Planning Application Ref: AW/43/18/OUT

Location: 261 Aldwick Road, Aldwick

Description of works: Outline application with some matters reserved for the demolition of existing dwelling and erection of two pairs of semi-detached houses and associated works

Mark Warwick
Tree Officer / Parks and Greenspace Team

Tree Constraints Plan
261 Aldwick Road, Bognor Regis

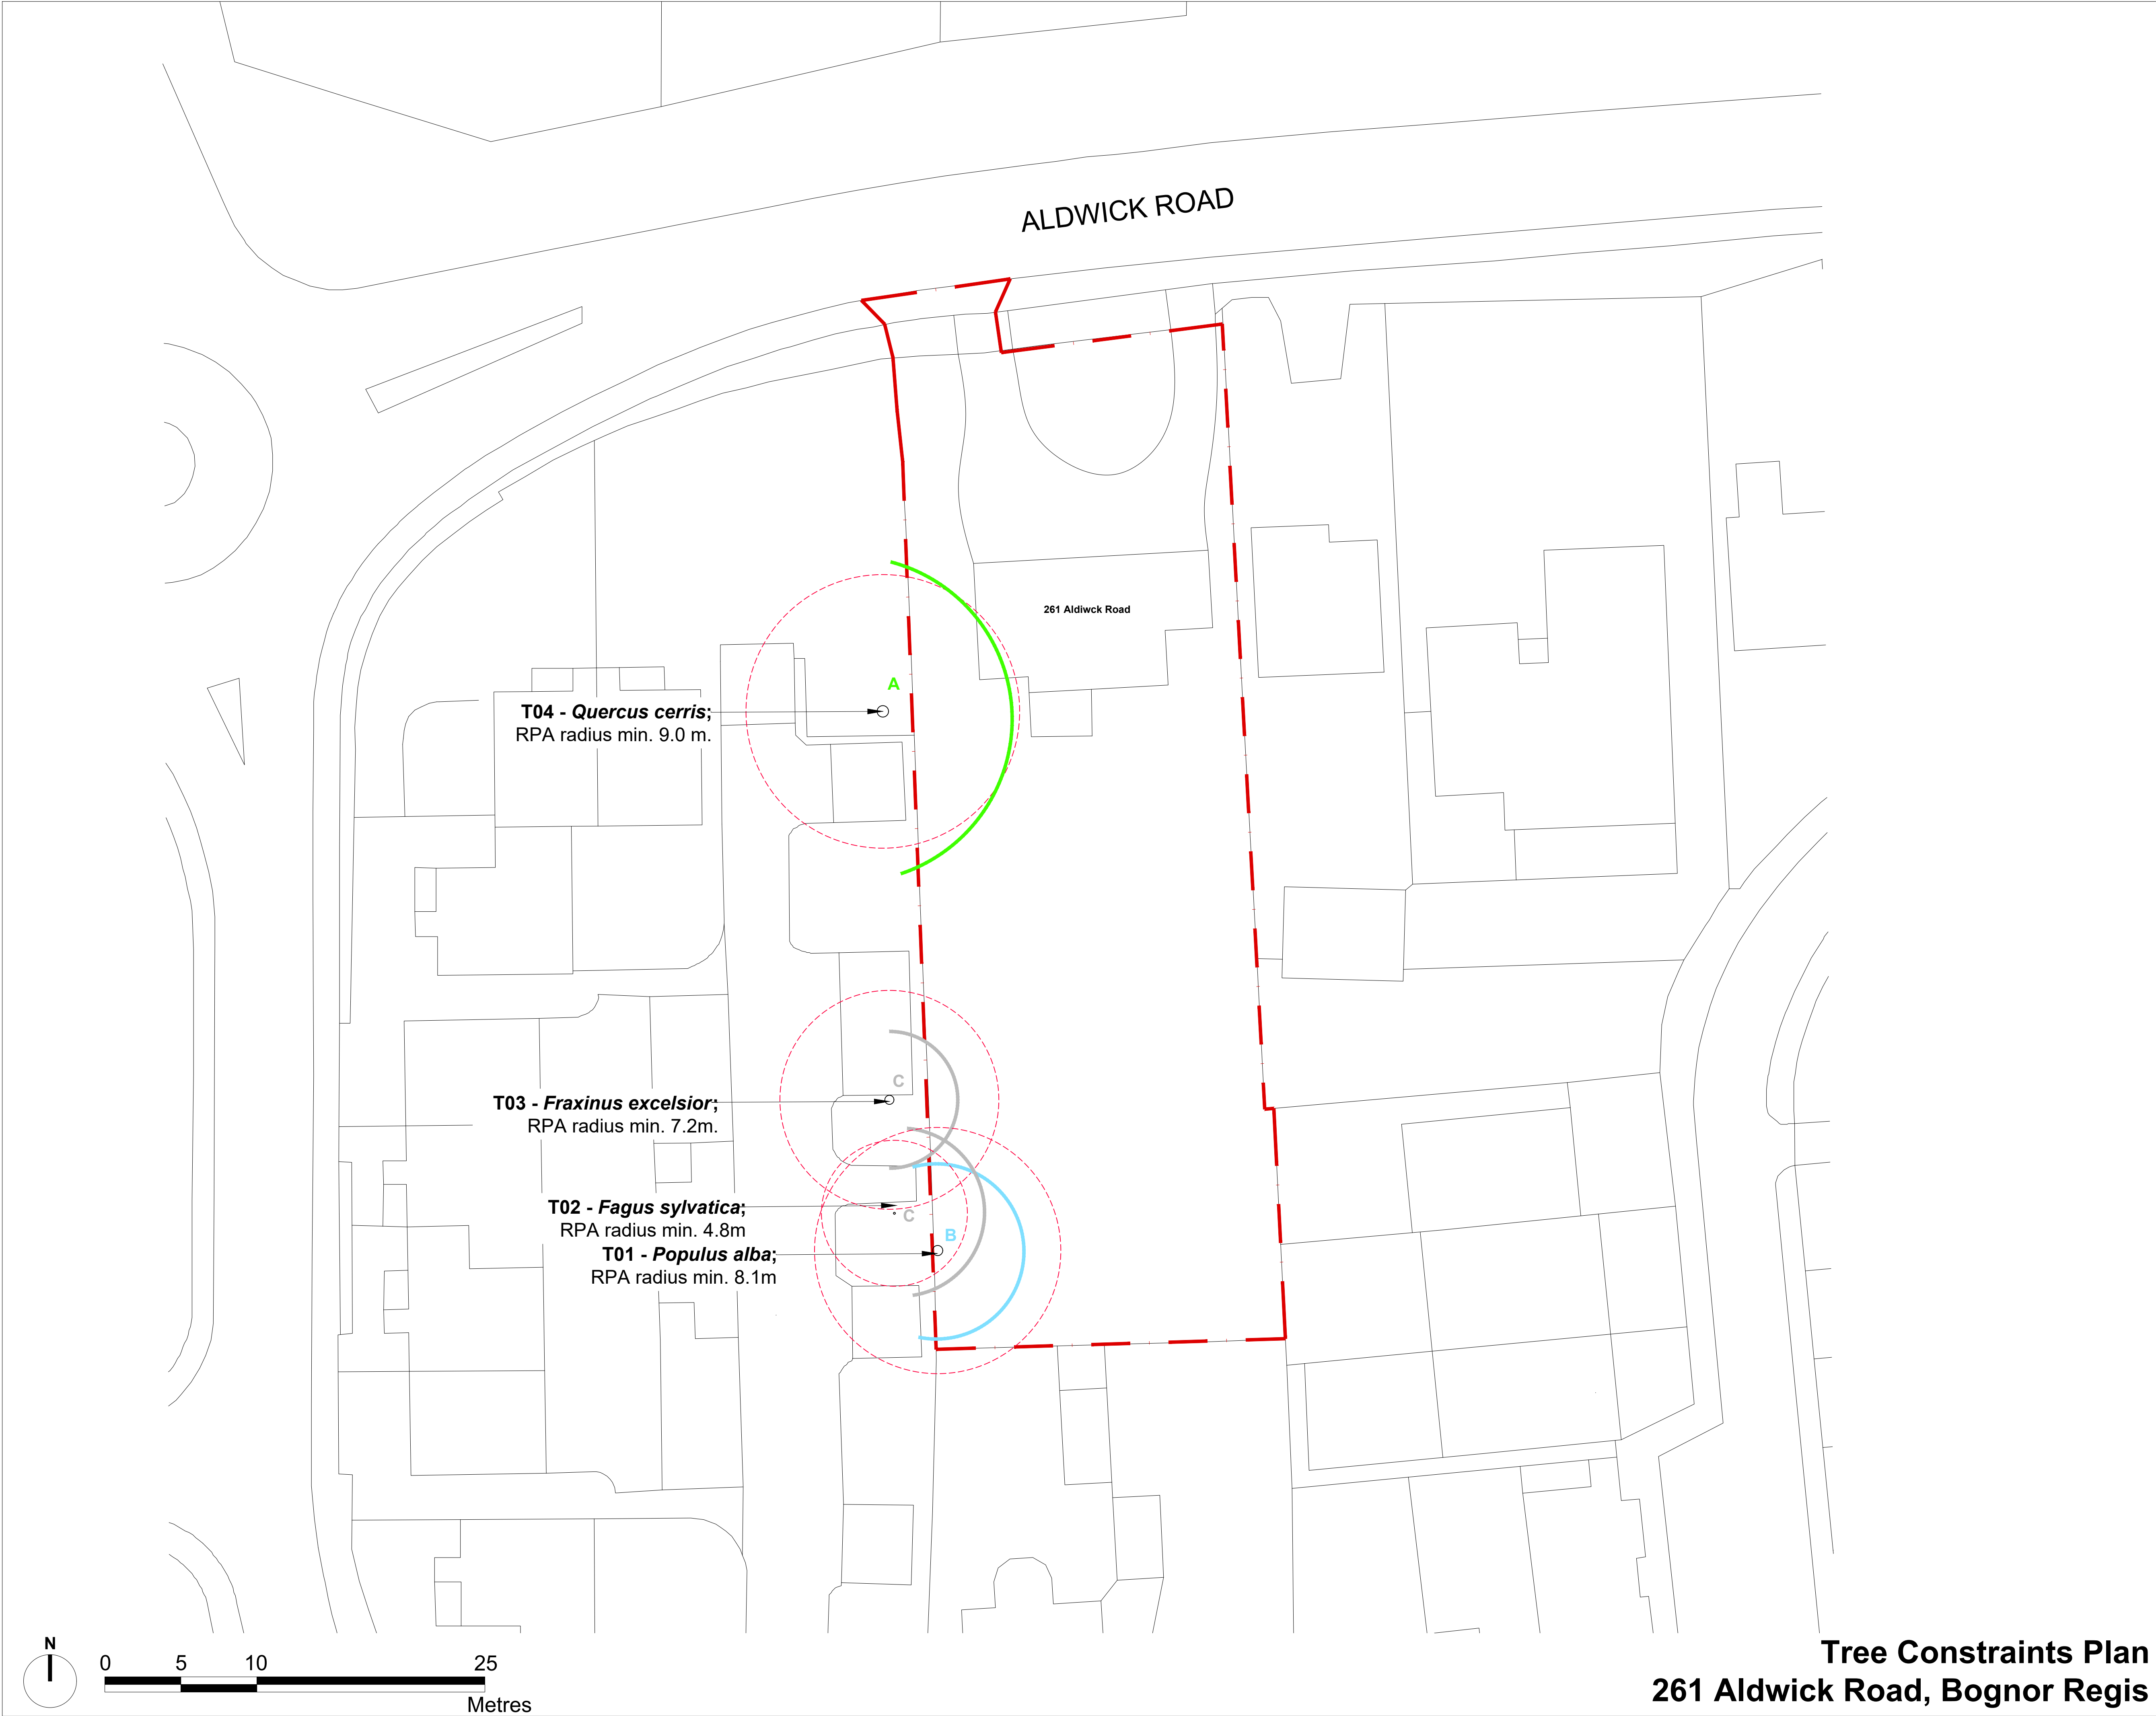
- The Tree Survey data so far as submitted accords with the requirements of BS5837:2012, although there are two notable omissions; namely two maturing sweet chestnut trees in the front garden of 259a Aldwick Road, the subject of a Tree Preservation Order (TPO/1/98/AW) and listed on the corresponding schedule as T1 and T2. [Resolved](#).

- I look forward to receiving a complete on/off site tree survey so that it fully accords with the requirements of BS5837:2012 and details mitigation measures where any RPA incursion is proposed (re: 259a Aldwick Road). [Resolved](#).

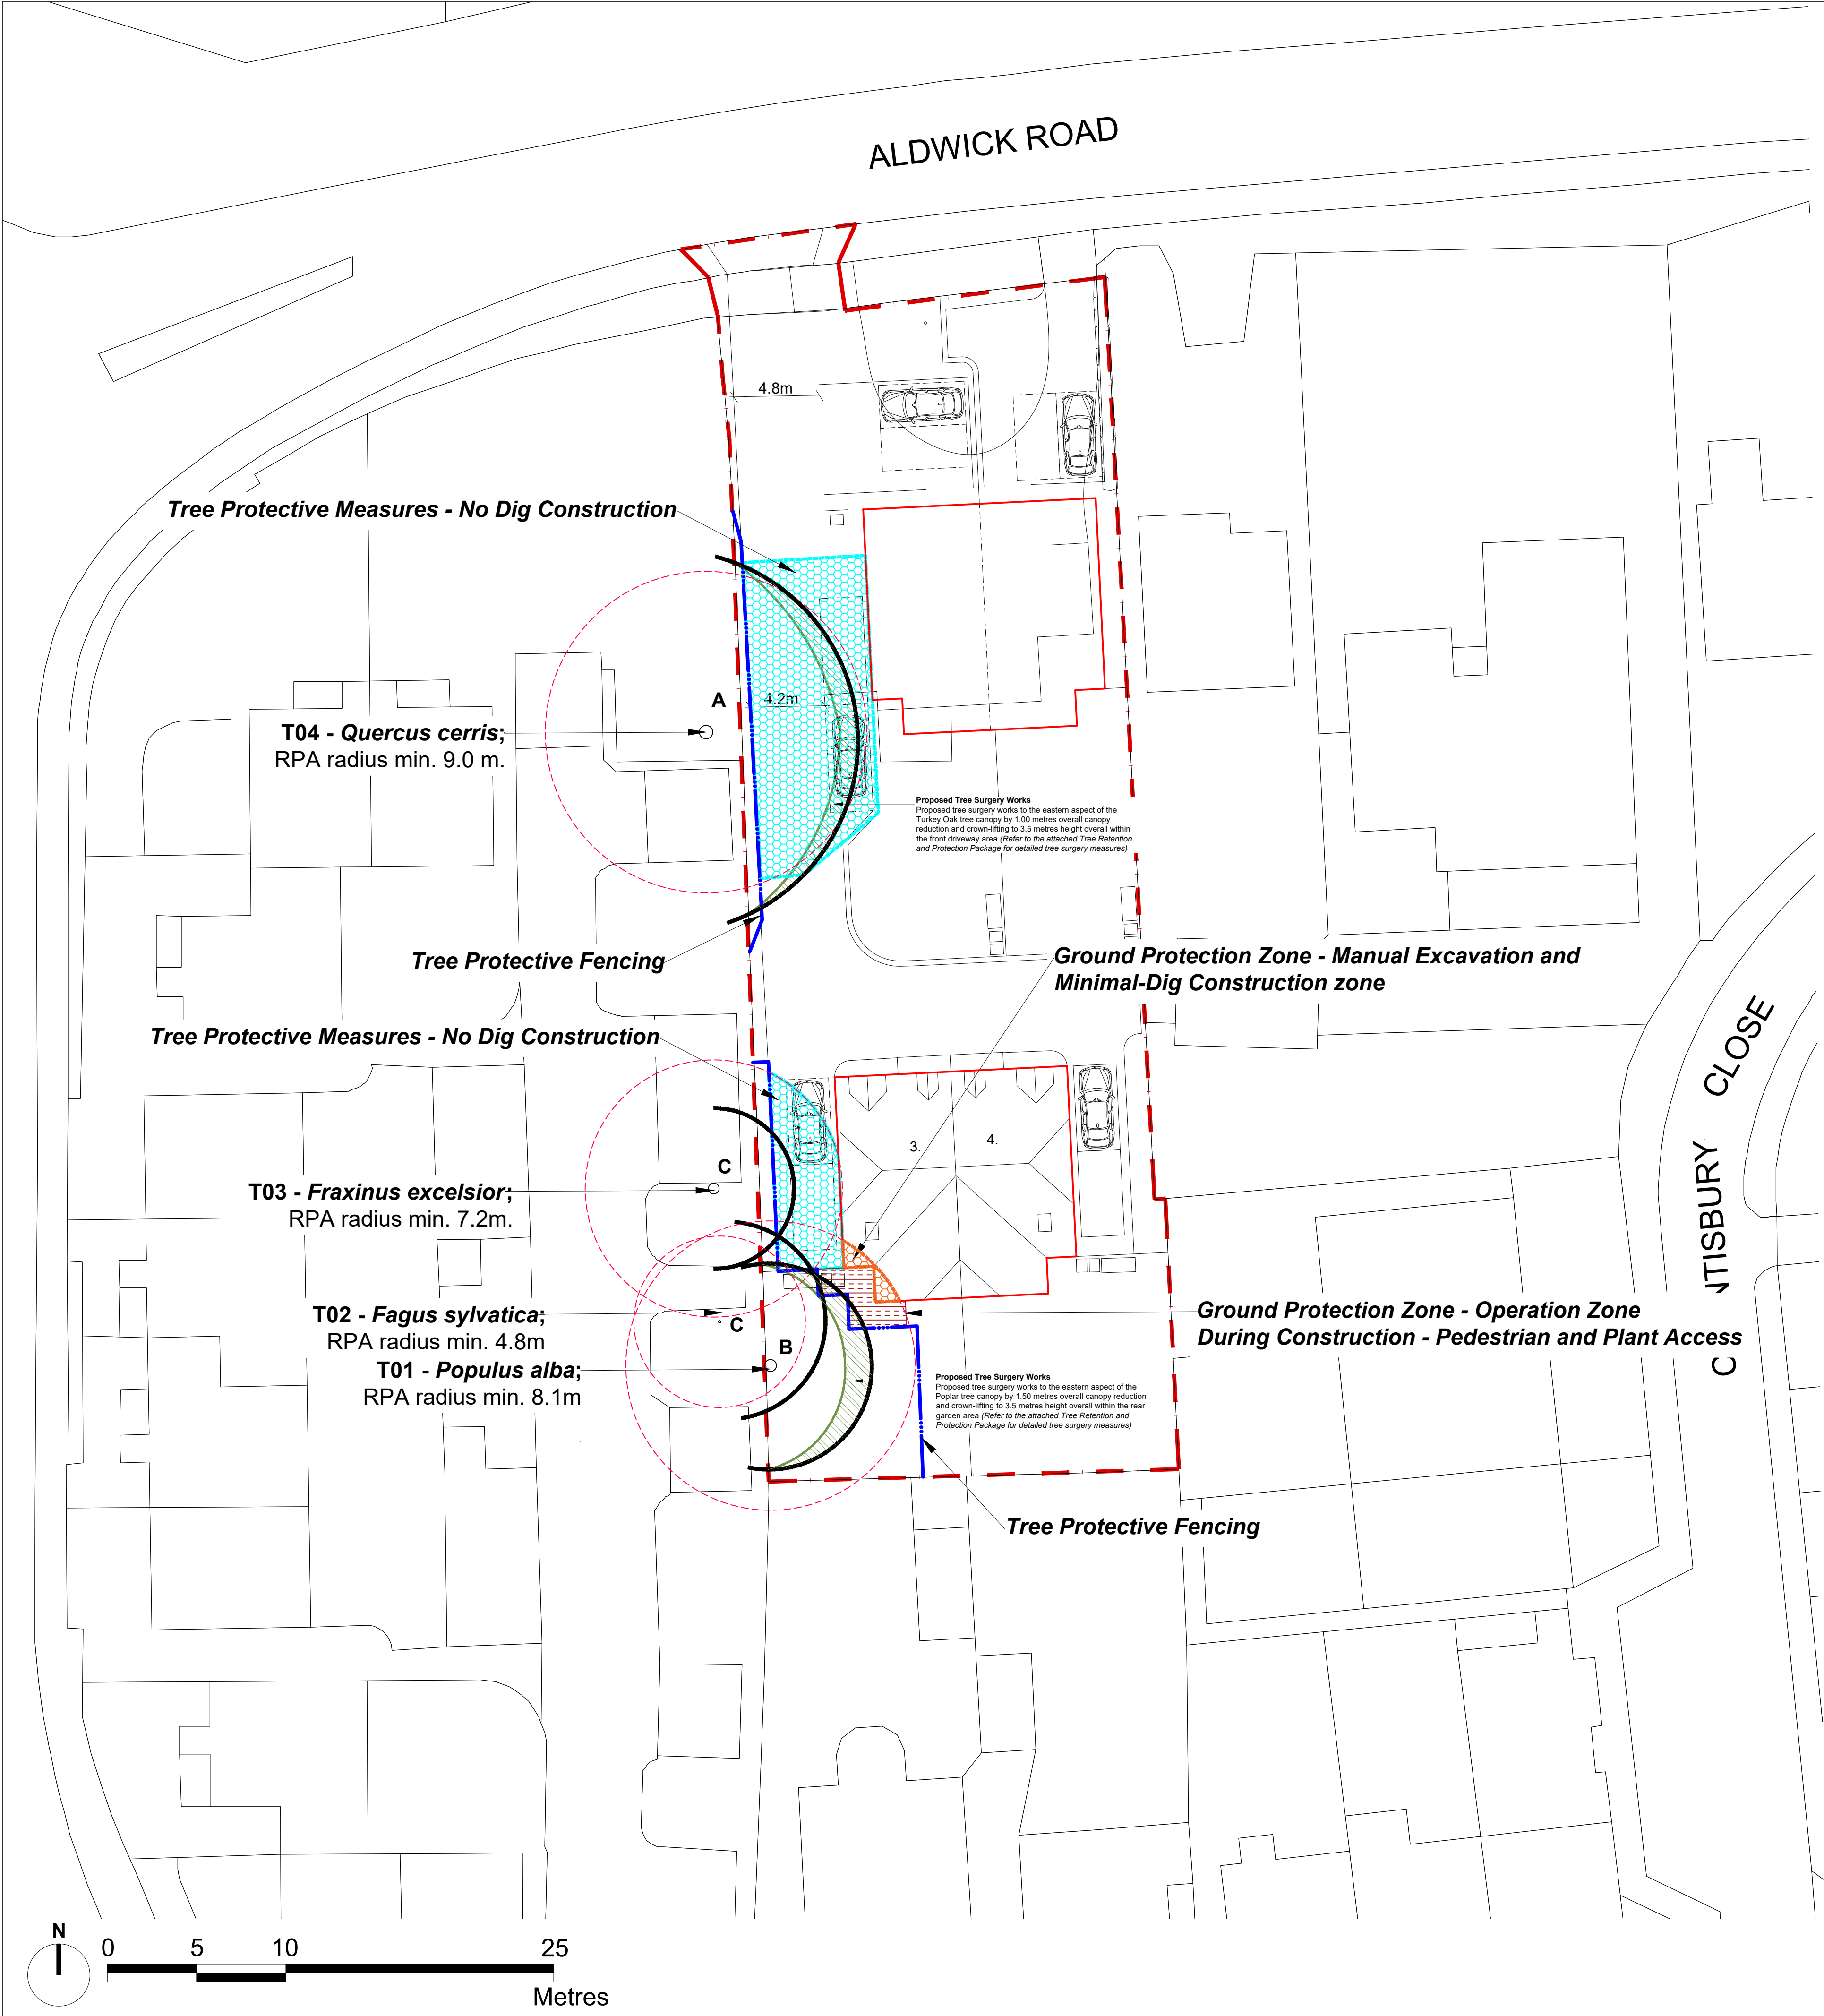
- T1 and T4 as shown on the **TPP dwg.no. LLD-ARB-DWG-002** are also the subject of an Order – TPO/AW/152/10, T-493 and TPO/AW/41/10, T-492 respectively. T4 has been incorrectly identified as a white poplar (*Populus alba*). A small matter; but for the record, it is a hybrid black poplar (*Populus x canadensis*).

- Crown reduction proposed for T04 (a fine and large example of oak) is simultaneously described as 'overall' and 'to the eastern edge of the tree canopy by 1.00 metres'. While the logical assumption is that only branches extending laterally to the east are proposed for pruning, the terminology used here leaves some room for misinterpretation and result in inappropriate work being undertaken. A reduction in top tree height usually occurs during 'overall crown reduction' – this is neither necessary nor desirable and would irrevocably diminish the tree's visual amenity.

I am especially concerned with the 'No-dig' Construction methodology as described in the AIA/AMS, 21/June/18, Rev 01 (p13, para. 4.29) which states that existing soft ground layers within Root Protection Areas are to be removed so as to provide the necessary construction depth and to meet with existing hard surface levels. This is not a 'No-dig' Construction.

The extent and depth of proposed ground level alteration has not been provided in detail or shown on any cross-section drawing, so we cannot be sure these trees will not suffer significant damage. RPA incursion for this scheme is substantial and mitigation measures need to be explicit and provide confidence that important trees will be adequately protected.

If they can resolve the above concern to our satisfaction, by way of demonstrating how a true 'No-dig' Construction can be achieved across the site at those three areas identified on their Tree Retention and Protection Plan, dwg.no.LLD-ARB-DWG-002, Rev00, 21.06.18 and clearly write this into their AIA/AMS and to correspond with the TPP; then I would be able to remove my objection and recommend approval subject to the following conditions being applied:

- Removal of the word 'overall' from all report/plan references to tree work specification (re: crown reduction), so as to provide absolute clarity for any tree-work contractor (arborist). **Resolved.**
- As it stands, I must register an **OBJECTION** as there is insufficient detail/provision of information to ensure significant trees will be adequately protected during the demolition and construction phases.
